Application Ref:	3/2026/0191			 Ribble Valley Borough Council www.ribblevalley.gov.uk
Date Inspected:	26/06/26	Site Notice:	26/06/26	
Officer:	LW			
DELEGATED ITEM FILE REPORT:				APPROVAL

Development Description:	Proposed removal of conservatory at rear and replace with single storey rear extension, replace hipped roof with gable to create loft space for bedroom, office and bathroom with rear dormer.
Site Address/Location:	9 Glendale Drive, Mellor, BB3 7BH.

DRAWING TITLE: **PROPOSED FLOOR PLAN - 001**

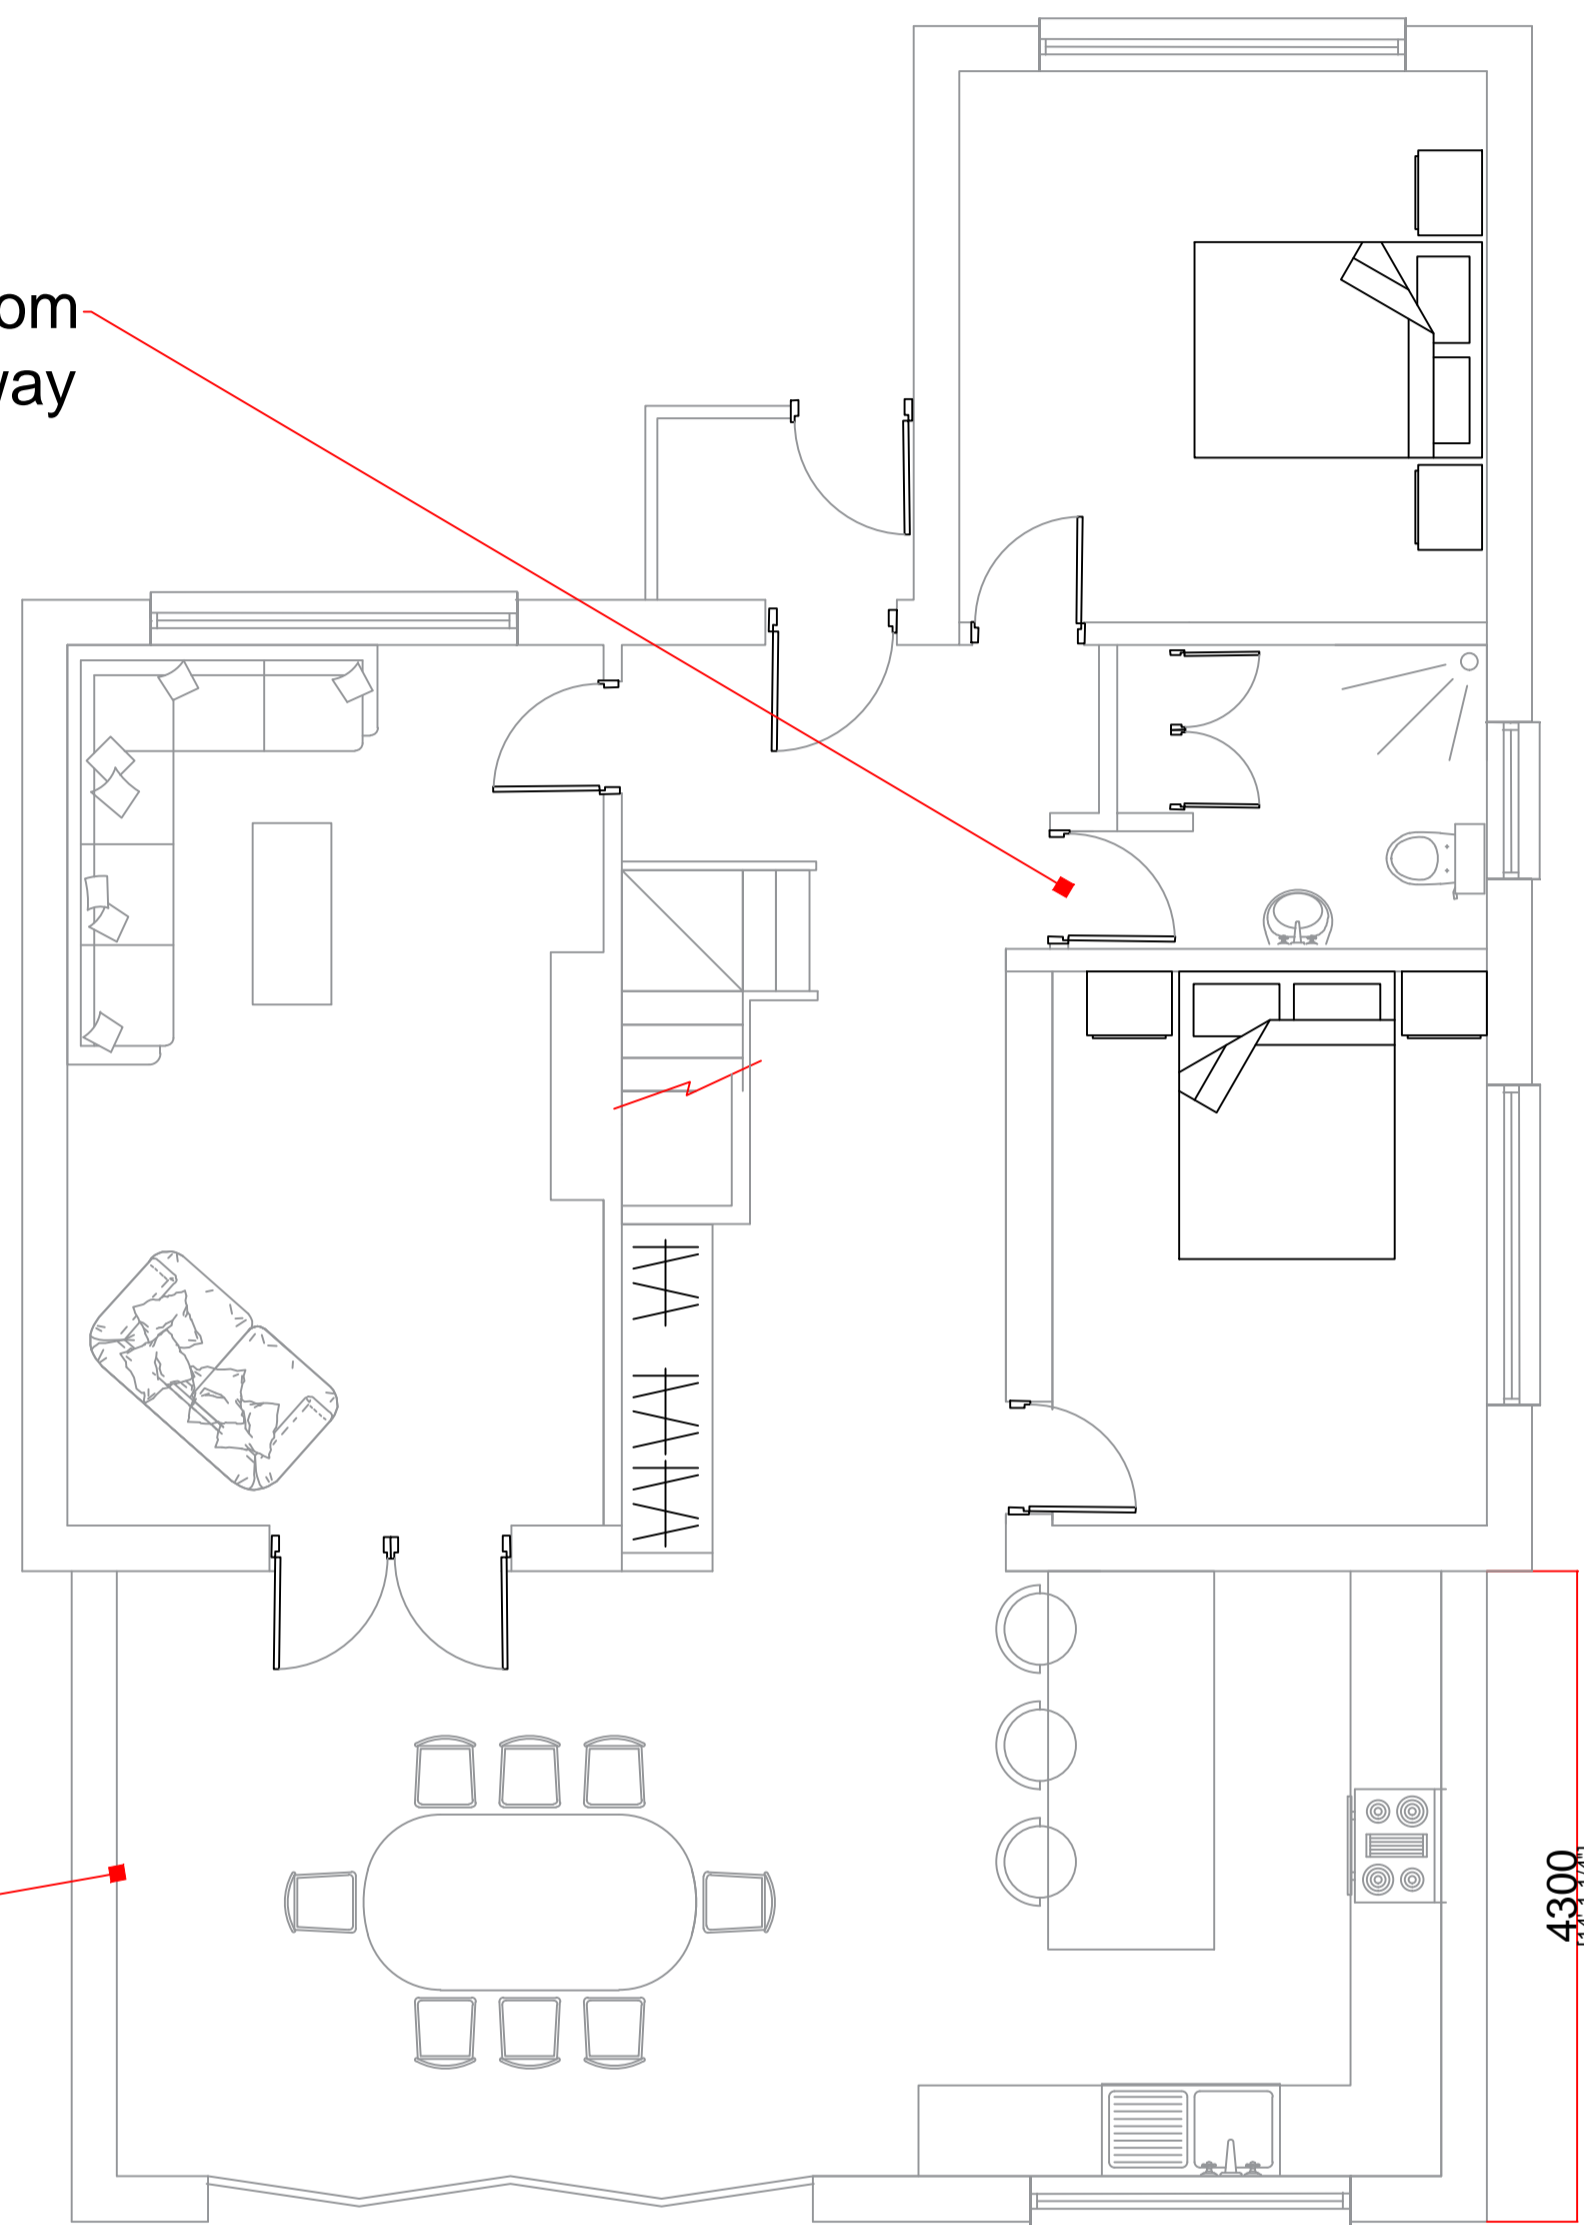
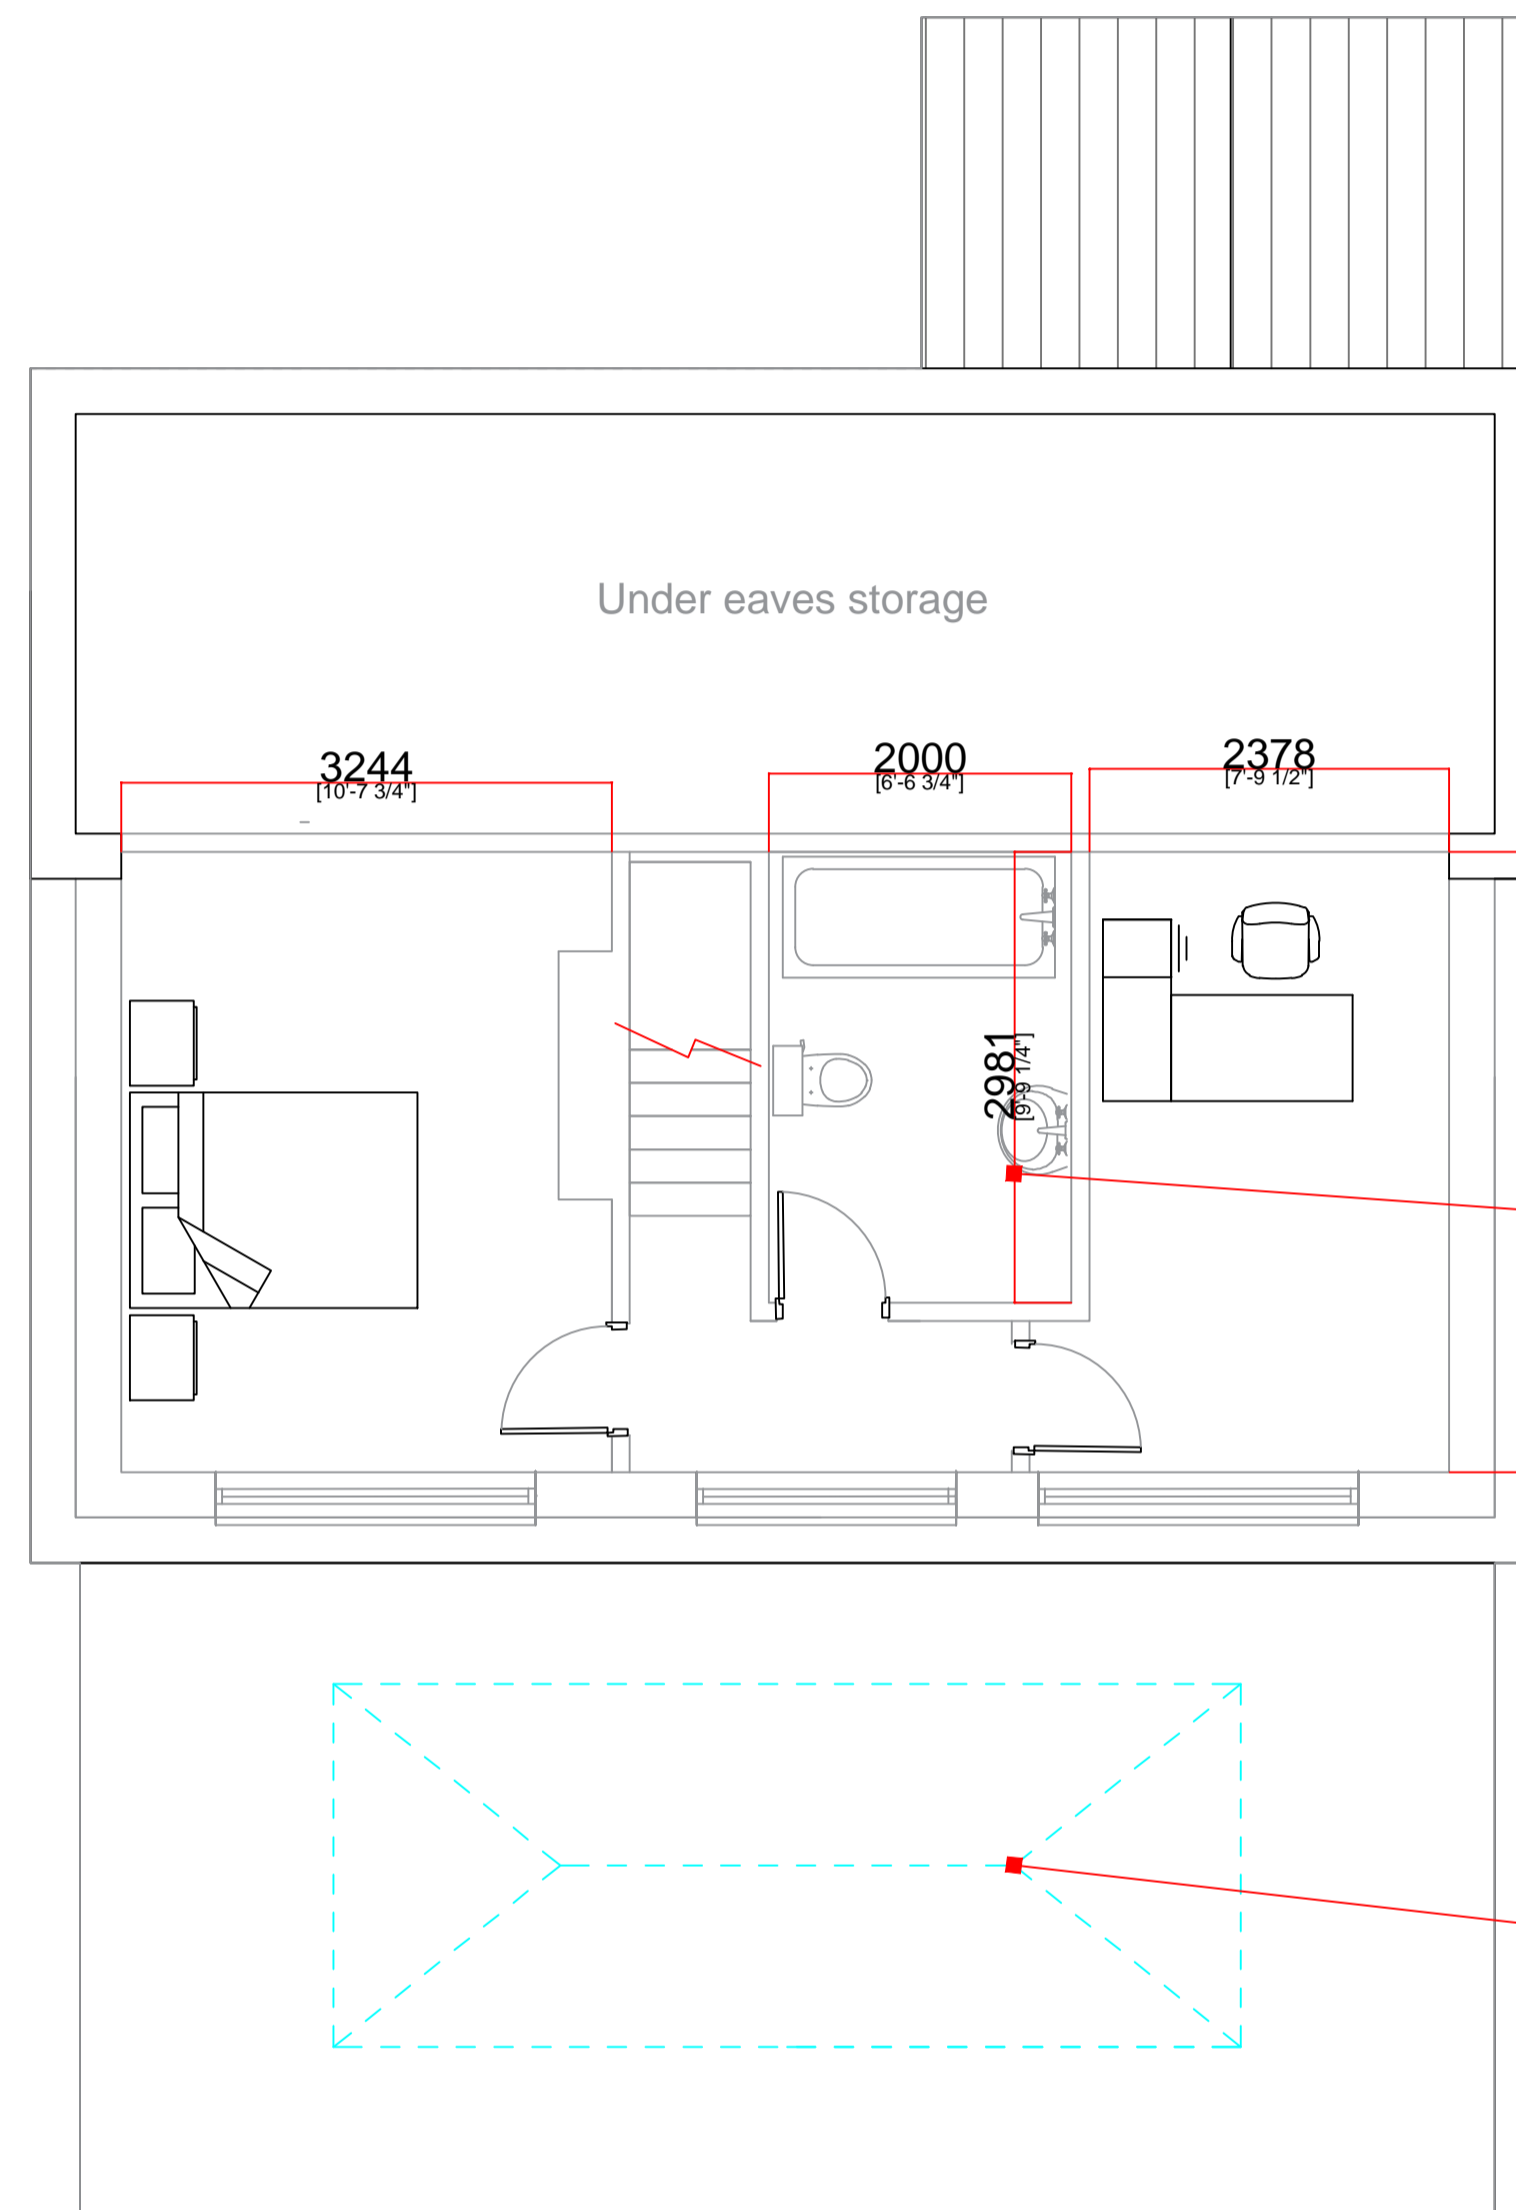
The proposed single-storey rear extension would project approximately 4.3m from the rear elevation of the host dwelling, with a width of 9.4m. It would feature a flat roof design with a maximum height of 2.9m. The rear elevation would incorporate bi-fold doors and a window opening, alongside a roof lantern within the roof.

The proposed openings to the single-storey rear extension would provide a similar outlook to that currently afforded by the existing conservatory, which it would replace, with views largely directed towards the application property's rear garden. As such, the proposal would not introduce any new opportunities for direct overlooking or result in a material loss of privacy.

The extension would align with the rear extension at the adjoining property, No, 11 Glendale Drive. Accordingly, it is not considered that the development would give rise to any undue impacts in terms of overshadowing, loss of outlook, or reduction in daylight. Furthermore, although the extension would be located within close proximity to the western side elevation of No.7 Glendale Drive, it would be largely screened by the neighbouring garage. It is therefore not expected to result in any significant loss of light or outlook to neighbouring habitable room windows that would justify refusal of planning permission.
